Scaldwell Parish Council objects to the proposed Green Hill Solar Farm on the grounds that it fails to comply with key national planning policy tests, presents unresolved environmental, safety, and transport risks, and lacks adequate legal safeguards for restoration, thereby rendering it unacceptable in its current form.

Title:
Figure 13.16: Access Locations for Sites and
Cable Route Corridor (South Area Part 2)

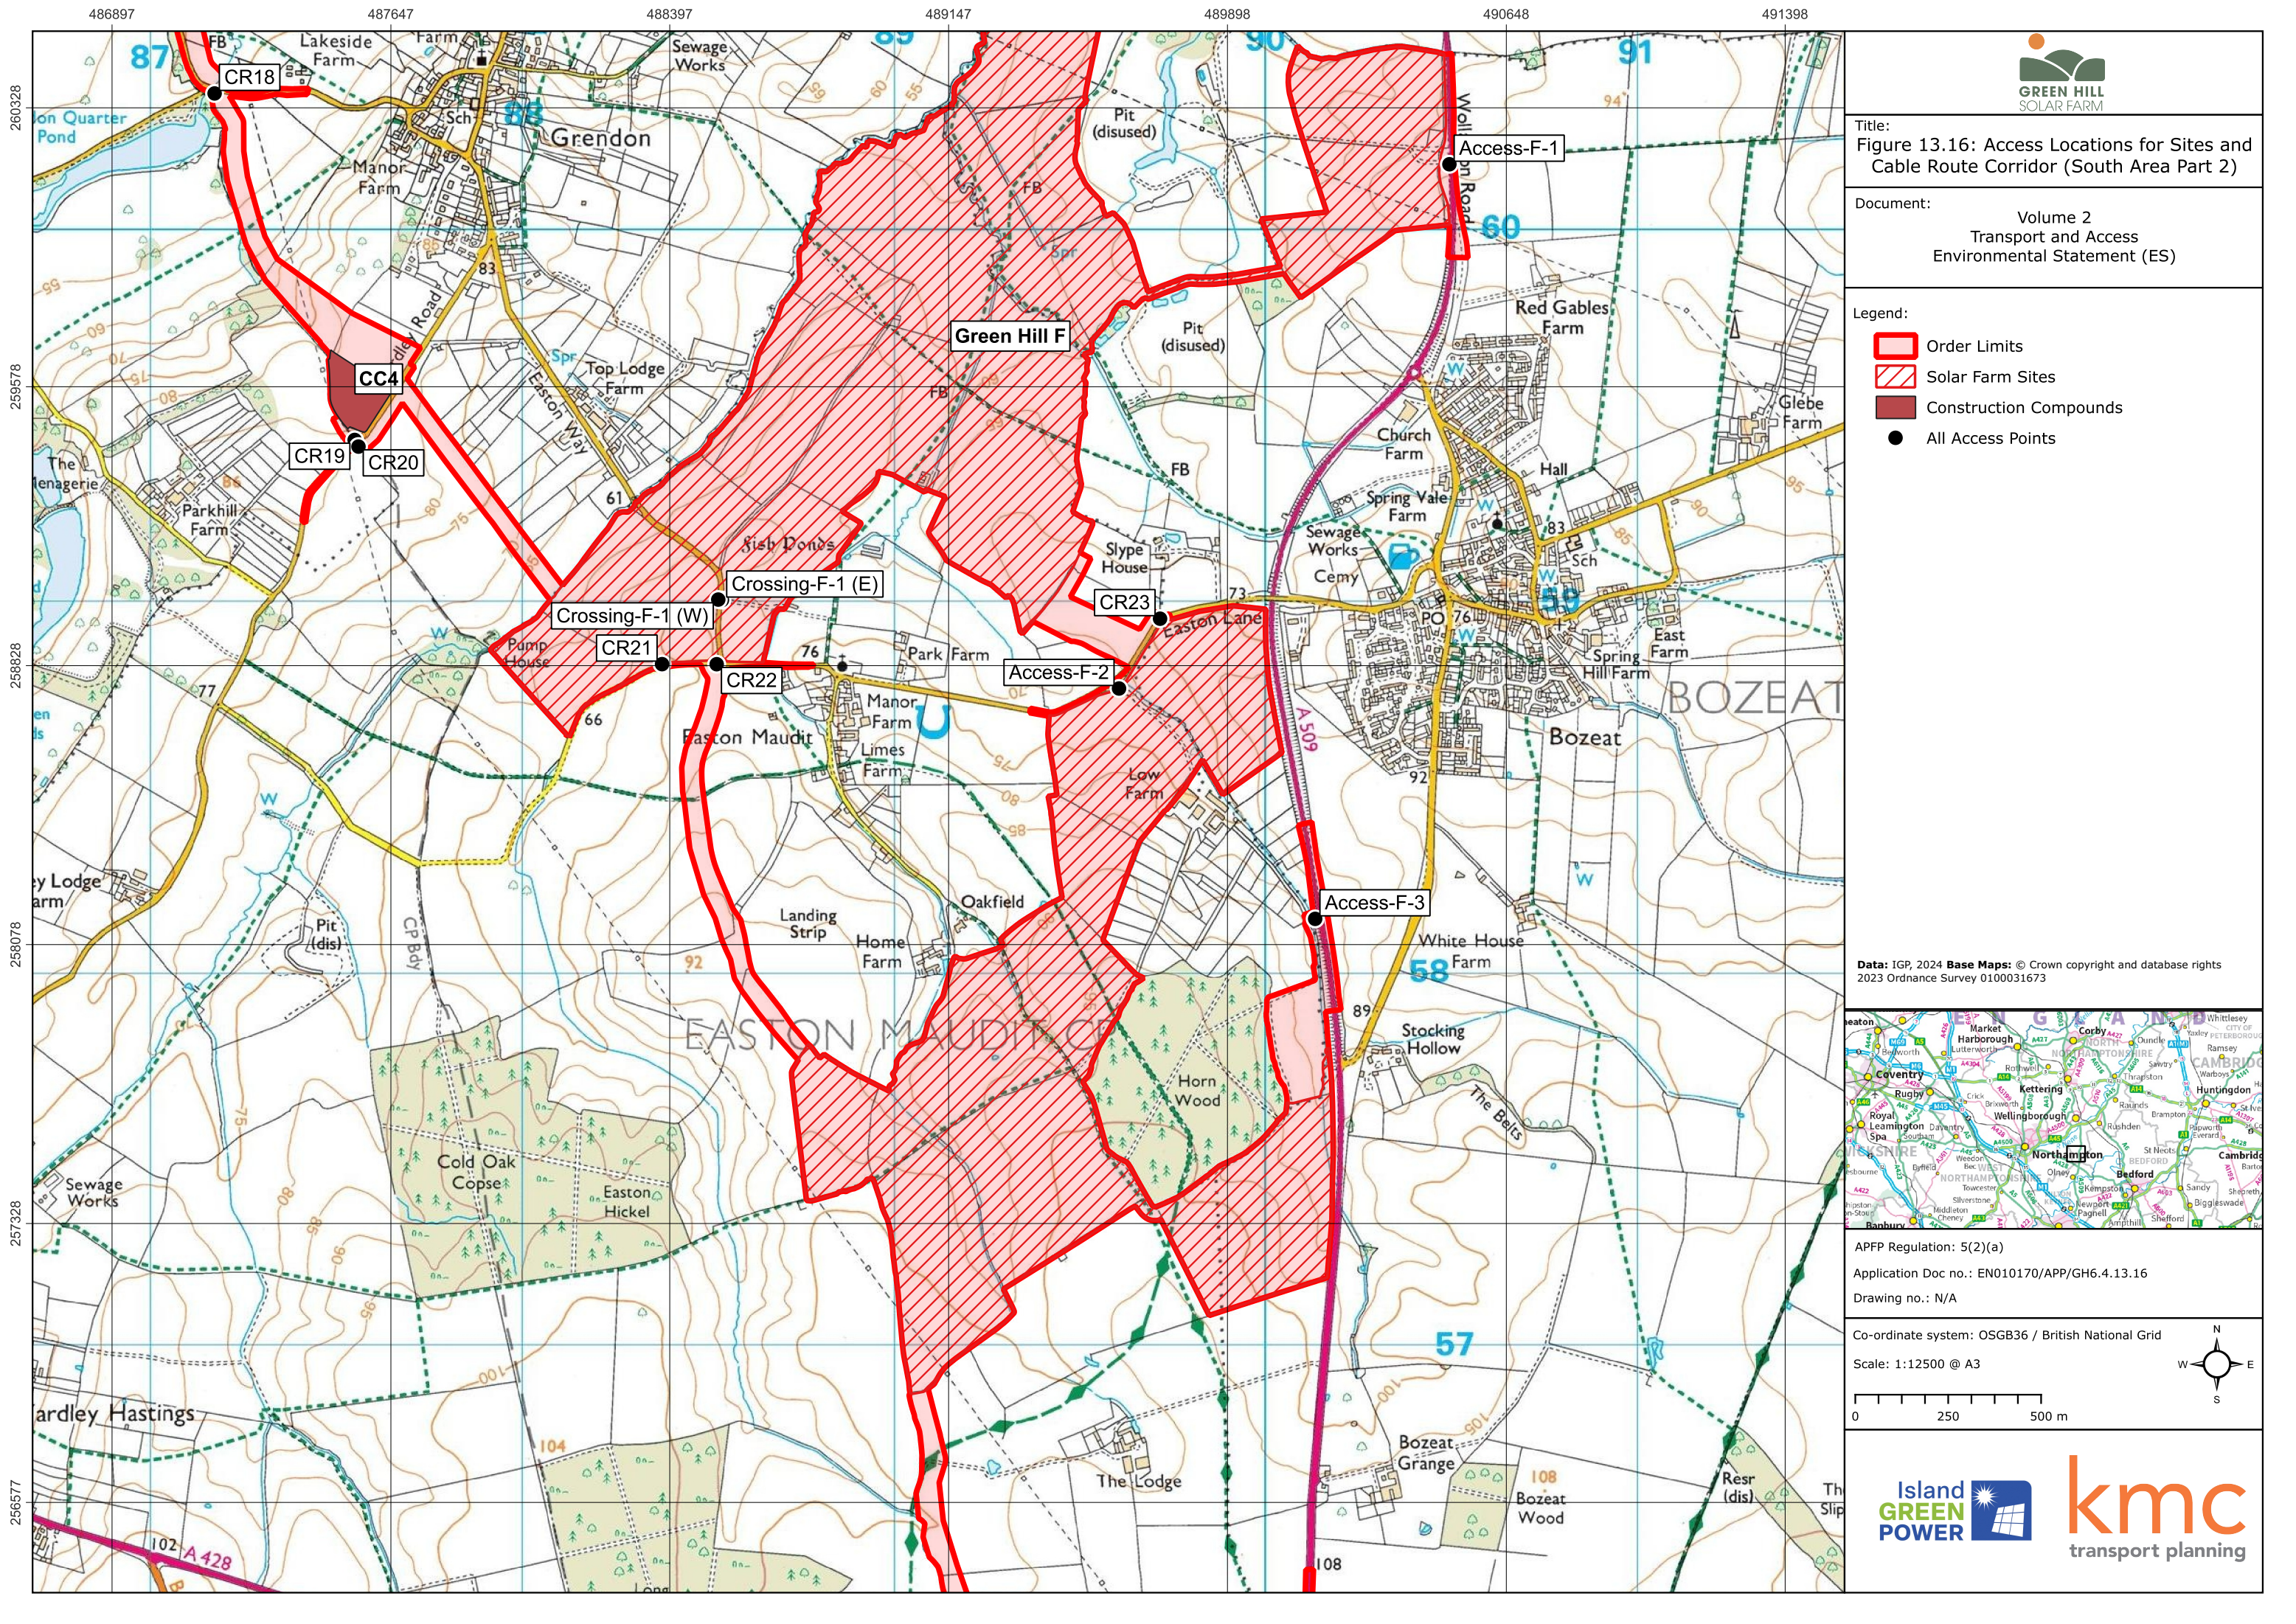
**Highway Access and Traffic Safety Concerns in Scaldwell** The Transport Assessment and associated ES chapters indicate that construction and maintenance traffic will access the site via a network of narrow, rural lanes with limited capacity, poor alignment, and restricted visibility in several locations.

The High Street is restricted to a single carriageway due to on-street parking along one side, creating pinch points and increasing collision risk when larger vehicles pass through.

The addition of construction traffic, abnormal loads, and long-term maintenance vehicles generated by this scheme will compound existing safety issues and congestion, with insufficient enforceable mitigation in the Applicant's transport proposals.

Scaldwell is a rural community with narrow, weight-restricted roads completely unsuitable for heavy goods vehicles.

Additional construction and maintenance traffic from the scheme will worsen congestion, damage roads, and increase hazards.
